Application for a Non-Material Amendment Following a Grant of Planning Permission

Ground Floor Plan
As Proposed

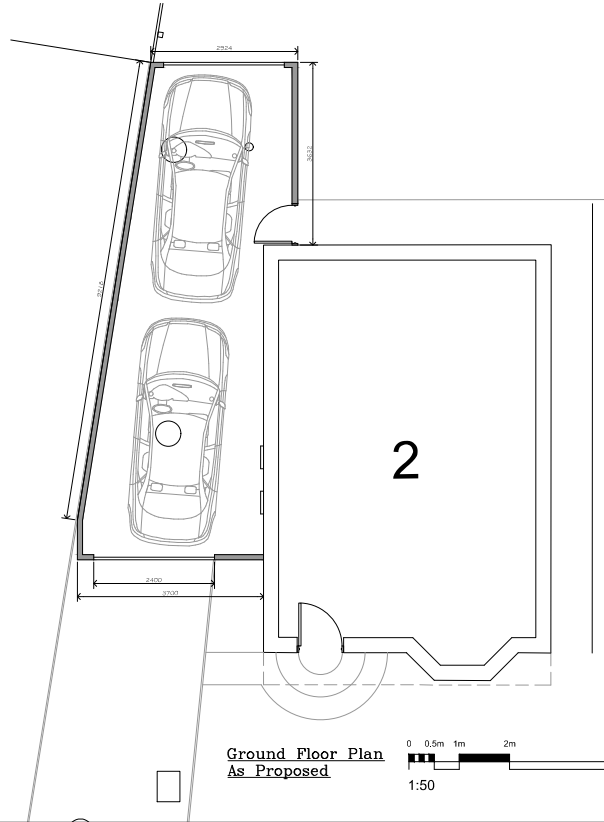
The rear side door to now be 150 cm wide instead of 120mm.
A removal of the rear roller door.
The non visible roof section to be a rubberised material

side door to aid in getting lawnmower etc through the garage.

removal of rear roller door as it will no longer be required due to the wider side door and for security reasons.
